In reply please quote: 15/19259
Your reference: SSDA 15_6917

**OAKDALE SOUTH INDUSTRIAL ESTATE, ERSKINE PARK, PENRITH
SSD 6917 – RESPONSE TO SUBMISSIONS**

I refer to the Departments correspondence dated 17 May 2016 regarding the Applicants Response to Submissions (RTS) prepared for the above State Significant DA for the Oakdale South Employment Lands (OSEL).

Eastern Boundary Landscape Section

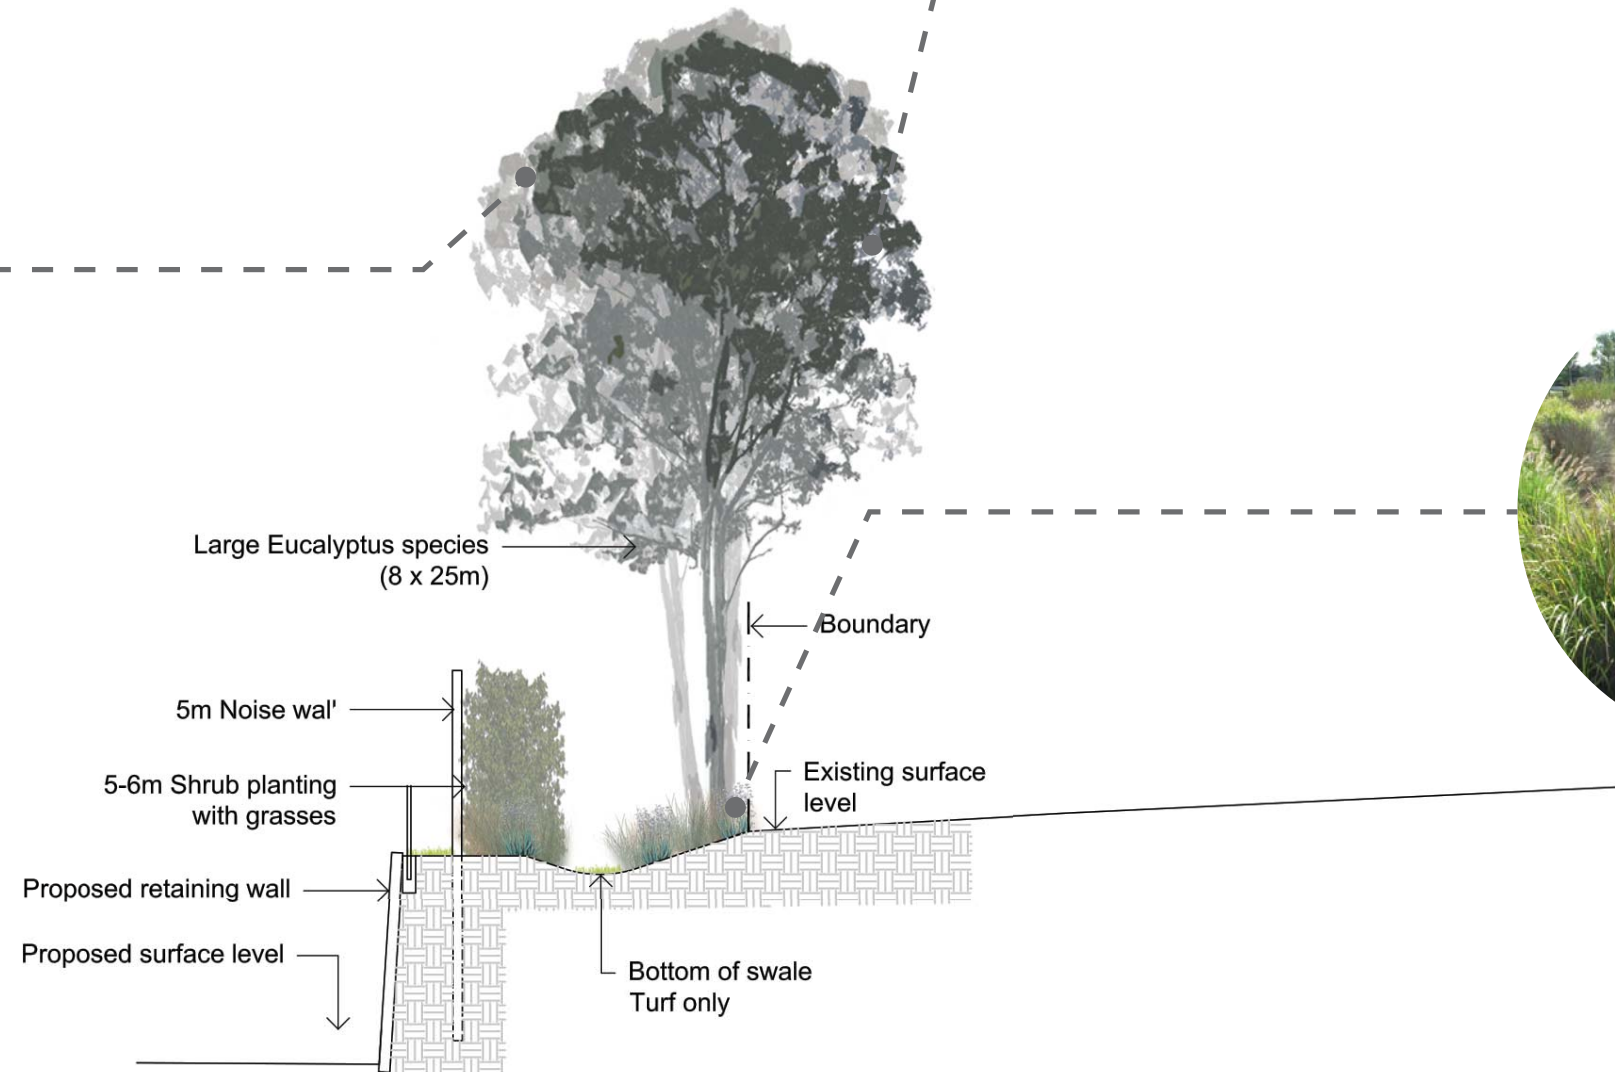
It is also unclear what the final width of the proposed landscape buffer will be along the entire length eastern boundary of the site. The cross section of the proposed noise wall would appear to indicate the buffer will have a width of 10m at one point, however it is unclear on both the architectural and engineering plans whether a 10m buffer has been factored in the design and construction of buildings along the whole of the eastern boundary.

- The final landscape buffer should be a consistent width (a minimum of 10m wide) and extend the entire length of the eastern boundary.
- The architectural and engineering plans should be amended to ensure that the provision of a 10m wide landscape buffer along the eastern boundary is factored into the design of the entire development.
